Accessibility Review Report – DA Review

Project Title: IC3 West Data Centre
17-23 Talavera Road, Macquarie Park

Report Version: 21302_ADR_DA_v1.3

DRAWING NUMBER
A2101

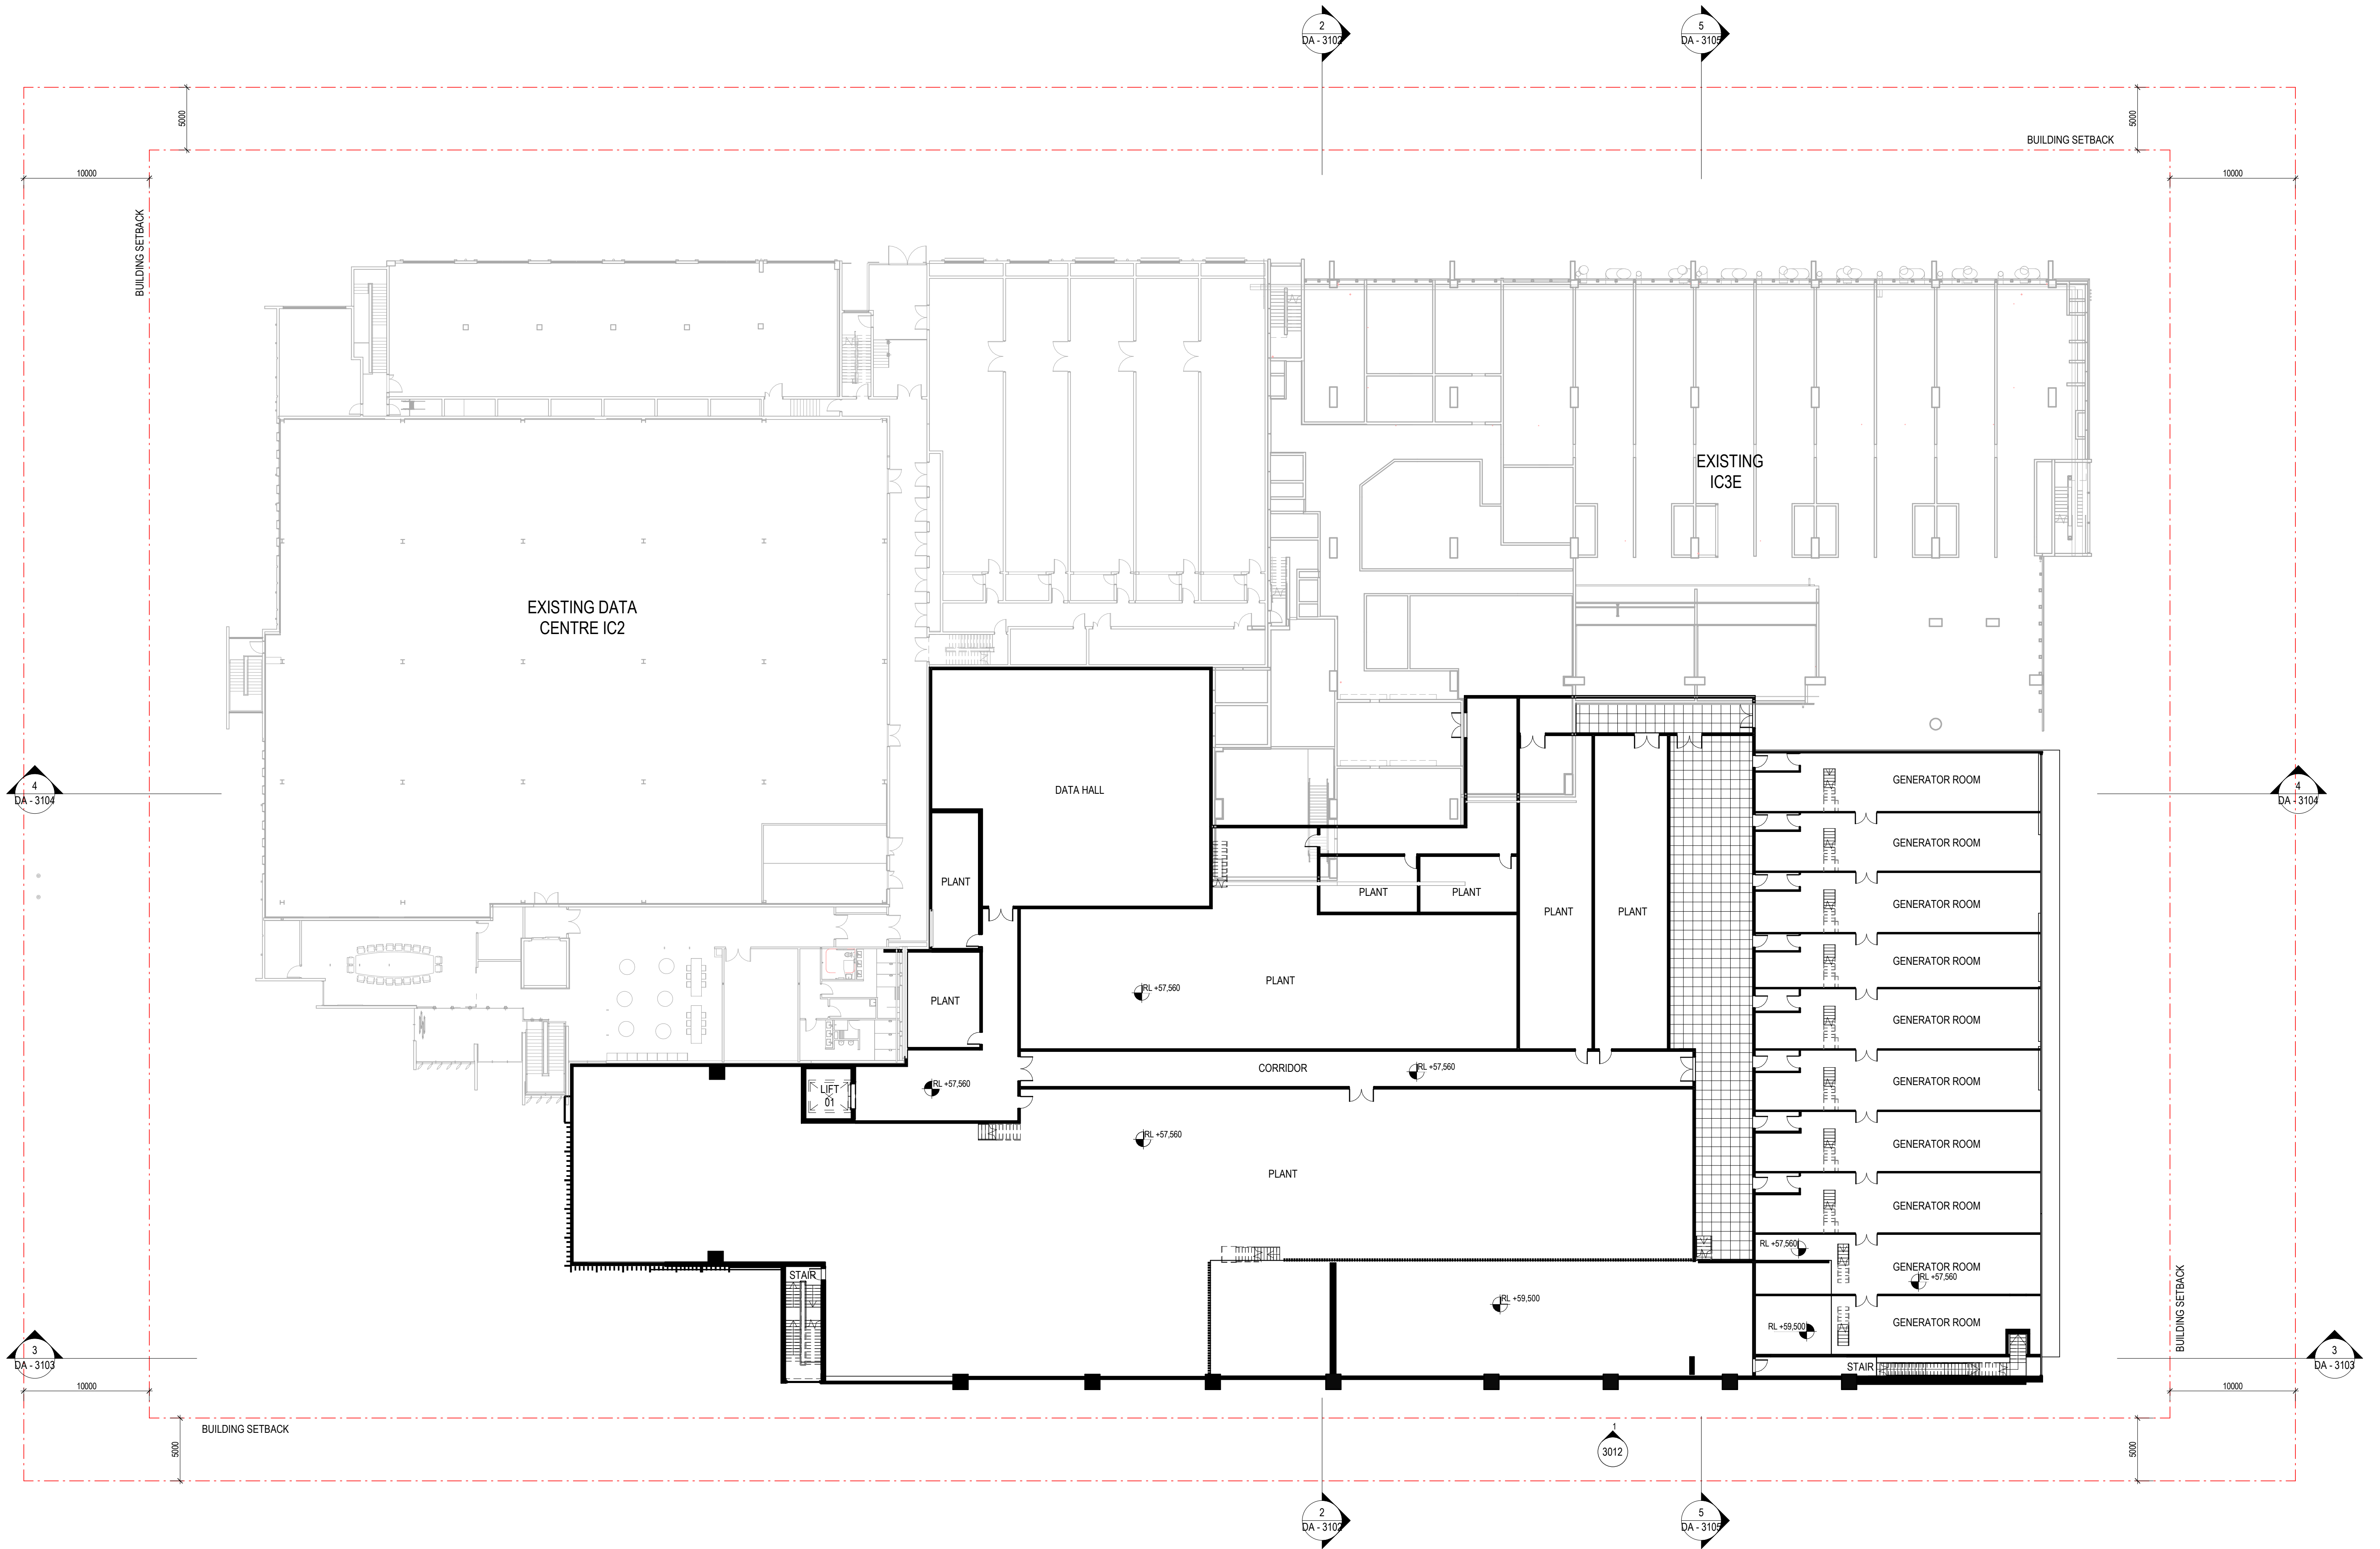
A compliant accessway (existing footpath) is not provided from the main point of pedestrian entrance at the allotment boundary to the building and via the Principal Pedestrian Entry (PPE) indicated by the red arrows below –

- The proposed compliance departure is proposed to be addressed via a Performance Solution. This is to be determined on a case-by-case basis and will require further development / discussion at the detailed design stage.

The accessway via the Principal Pedestrian Entry to the new passenger lift (Lift 1) is required to comply with BCA and AS1428.1-2009 due to the “affected part” provisions in the Premises Standard. An audit will need to be completed to verify compliance and address the following key issues:

<ul style="list-style-type: none"> • Access via the PPE (i.e. doorway design/details, door hardware, visual indicators etc.). • Access through the existing security gates (gate width and card reader locations). • Access via the existing corridors and doorways leading to the new passenger lift. <p>Refer to “affected part” in green below:</p>  <p>The following will need to be detailed at the design development stage:</p> <ul style="list-style-type: none"> • Ensure access via the PPE complies with AS1428.1-2009. • Access via the security gates is to allow for a compliant 1m path of travel and swipe card readers at the prescribed locations. • Doorways to achieve an 850mm clear opening width and circulation as prescribed by AS1428.1-2009. • Doorway design including hardware, opening force and contrast to comply with AS1428.1-2009. • Travel (i.e. circulation, floor finishes etc.) via the existing corridors and doorways to comply with AS1428.1-2009.

The above will apply to the proposed ramp on the Ground Floor between the main entry and the carpark.
